Application No: FG/82/21/PL
Site Address: 11 Ferring Marine Ferring BN12 5PP
Description of works: Variation of condition imposed under FG/127/19/HH relating to approved plans.

Thank you for your internet representation made on 14th May 2021 which has been recorded as an objection with the comments as follows:

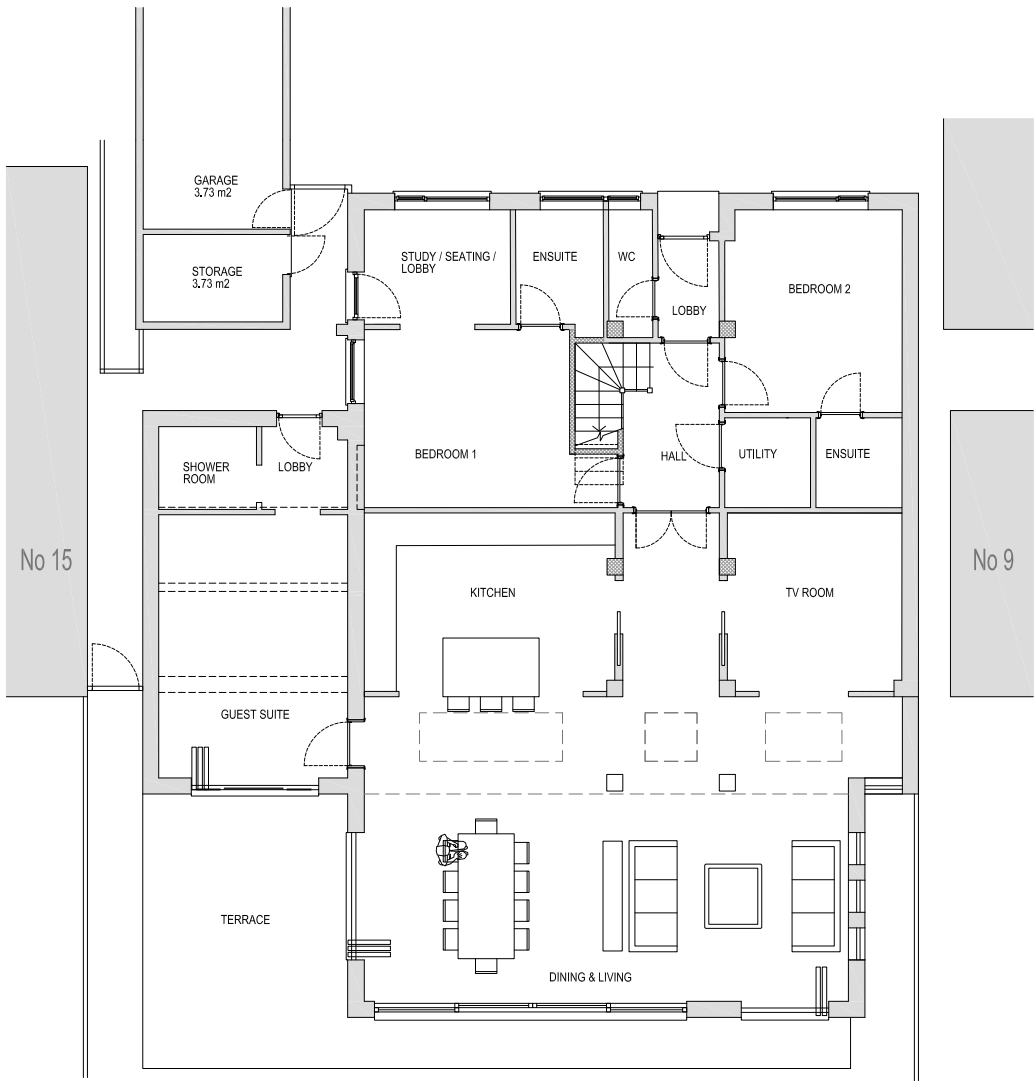
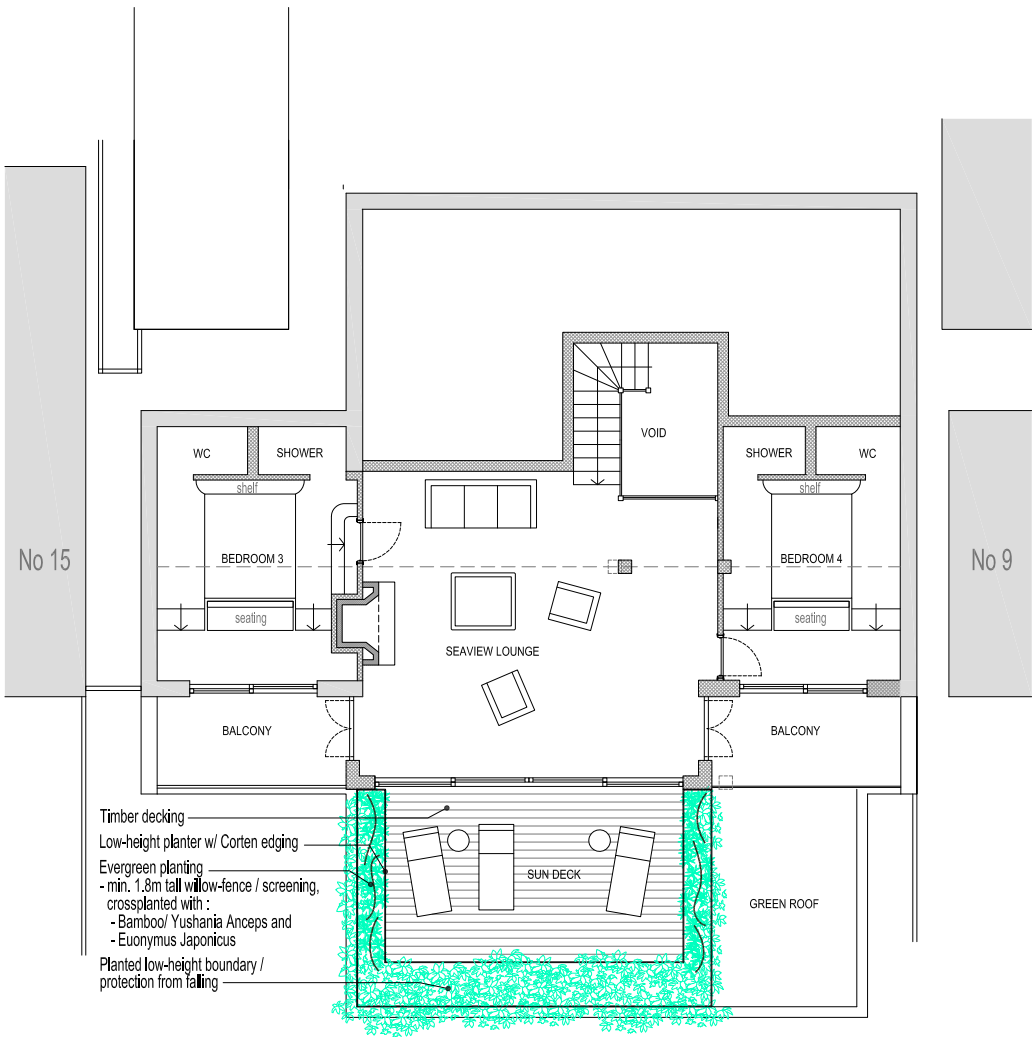
It's my understanding that the building extension was given approval only because it was not supposed to have a useable balcony above it. I found this odd as there was going to be so much space created and with the views to the sea - they would want outside access.

PROPOSED
ELEVATIONS AND
MAIN SECTION

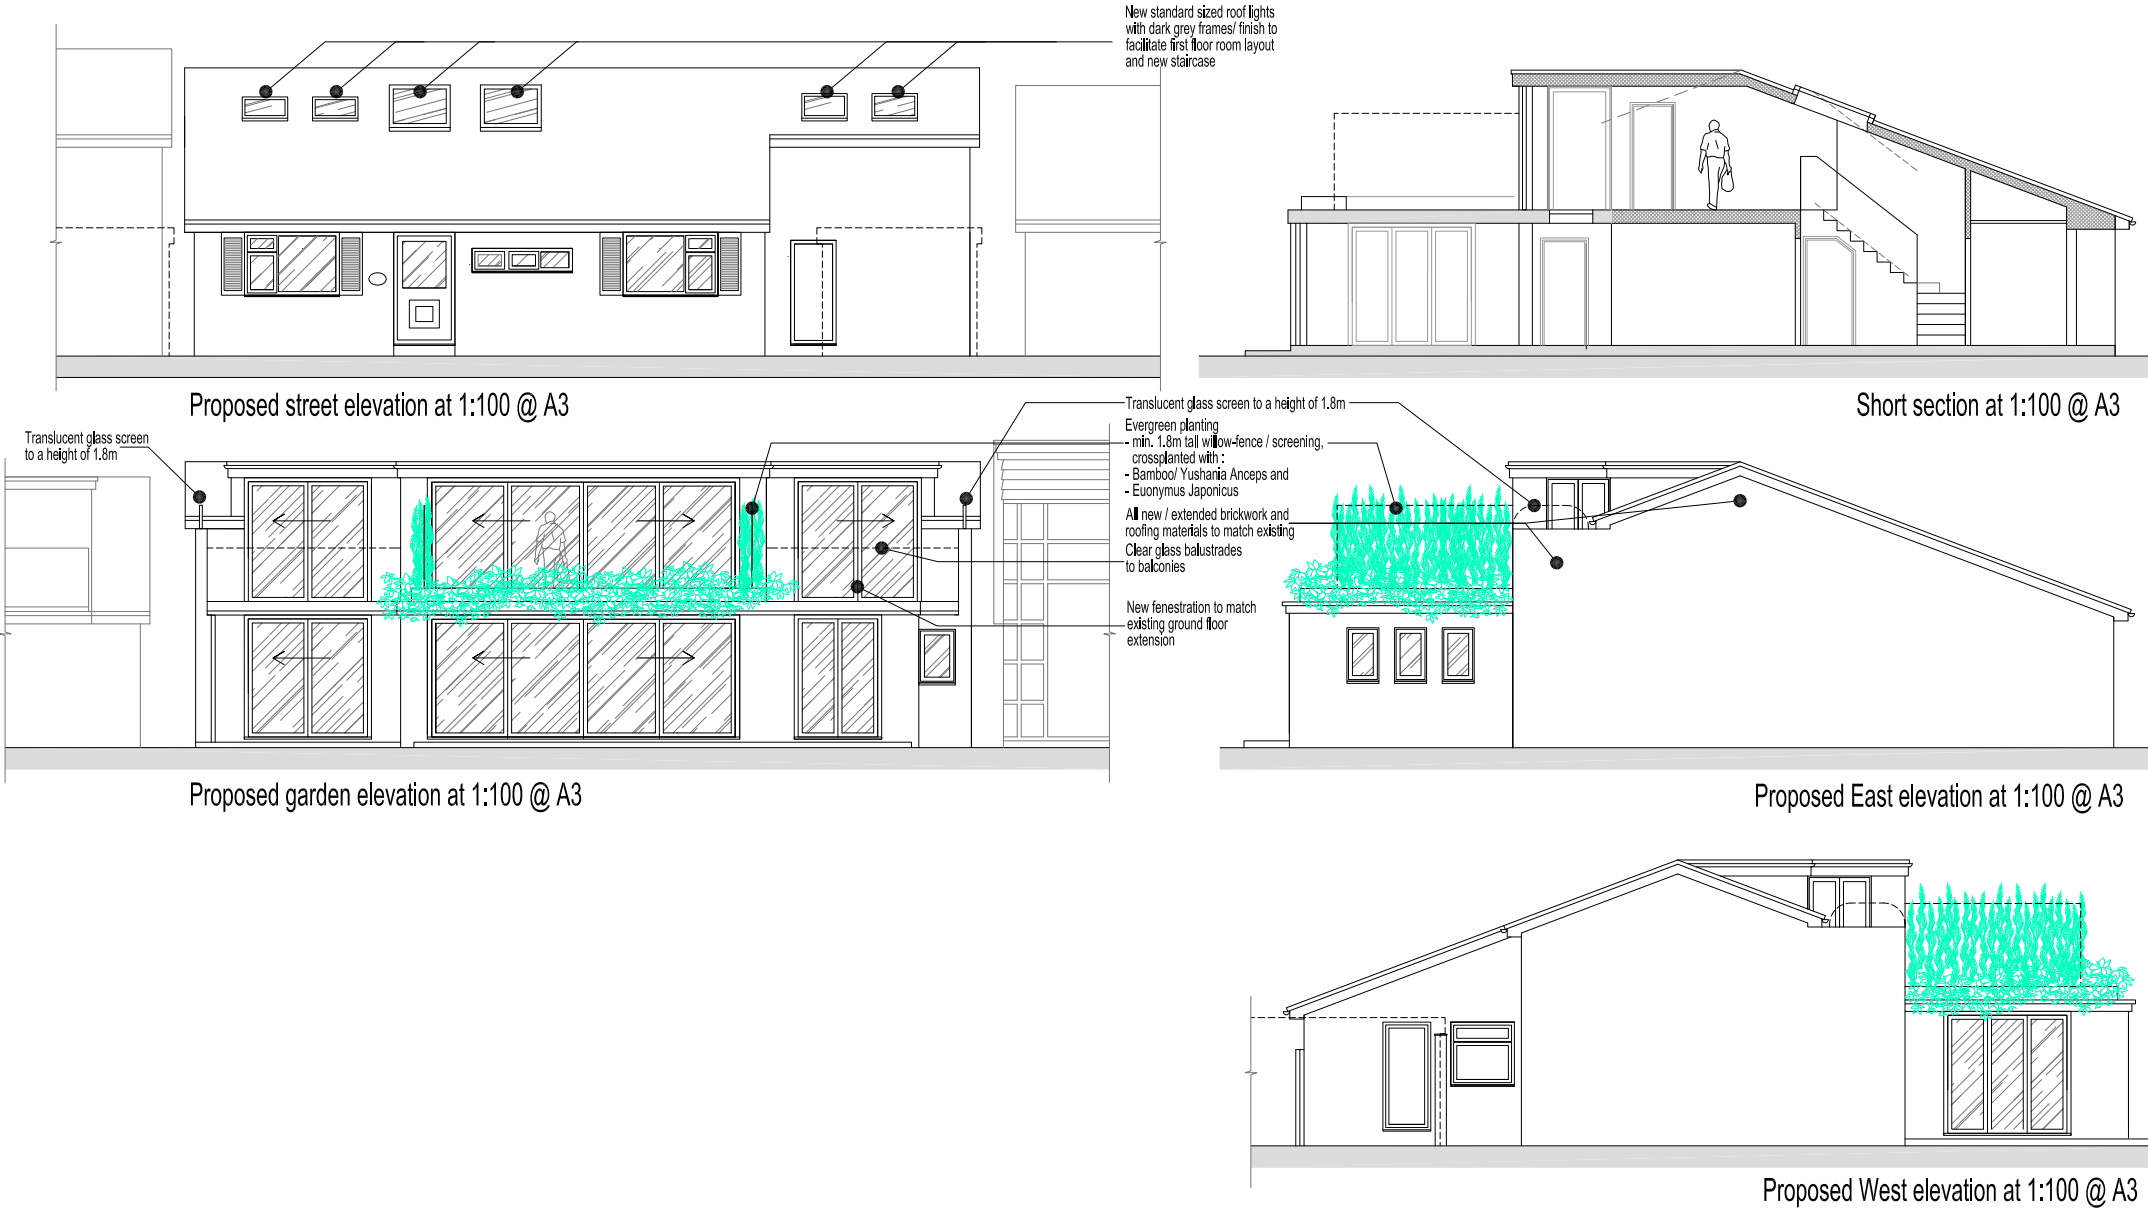
It now appears - with the planning application for 1.8 m high green screens either side of this 'non used' space that the owners are going to use it as a balcony and not as a 'green roof' as initially approved.

So, how does this work, initial application = we're not going to use the balcony and we'll have a eco friendly green roof. Now, second application = we'd like to use the balcony and since we have the available space, we'll just put up some green privacy screens on either side and the neighbours won't object?
